Subject: FW: EP/179/18 Gladwyn, The Street, East Preston

We appreciate the efforts to provide the requested information so far on this application, however, on consulting with our Conservation specialist and having now reviewed the design and the material considerations of the appeal decision for 9 Line Tree Close (14/03/19), the officers consider your application misses a vital assessment on design impact and fails to recognise the importance of its setting.

Drawing: Street scene

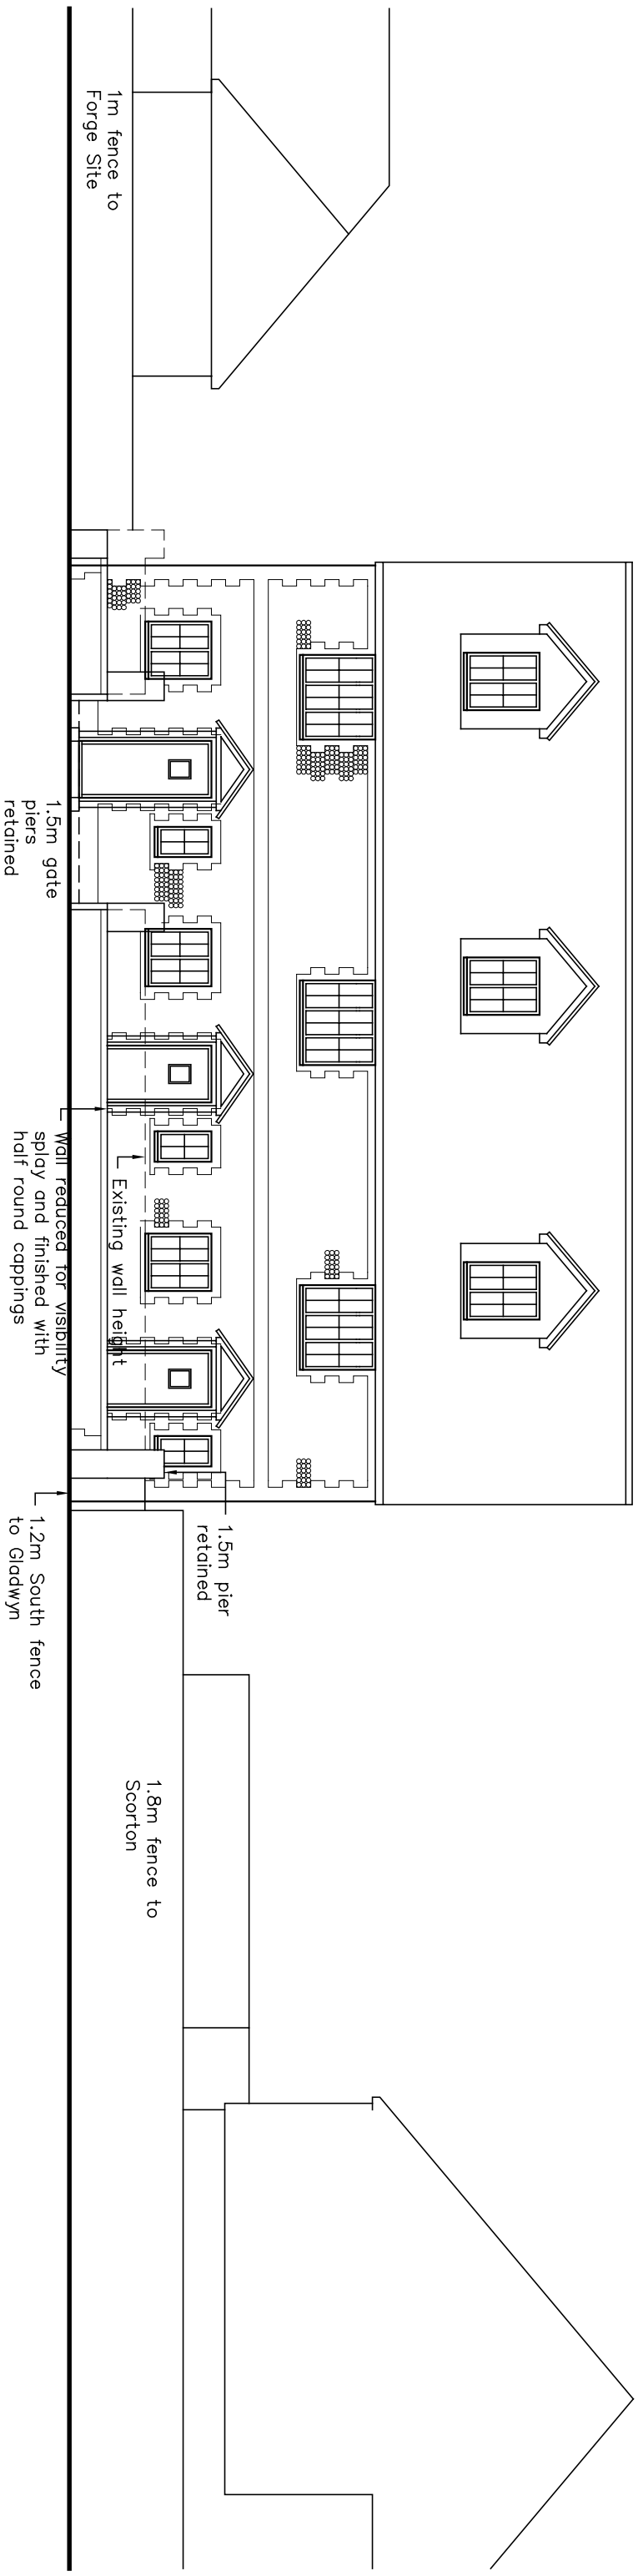
No.9 line tree Close although closer to the road frontage, the cottages facing onto The Street have been designed with a scale, proportion and material pallet that sympathetically reflects upon the immediate setting and fits well with the requirements of the Local Plan Neighbourhood plan on design with Heritage being a further consideration to ensure the scheme responses well to the local vernacular.

As there is a clear lack of information to support your applicant and the importance of context including its impact on heritage assets, for these reasons the scheme is considered contrary to NPPF and the policies of the Arun Local Plan and Neighbourhood plan and shall be refused.
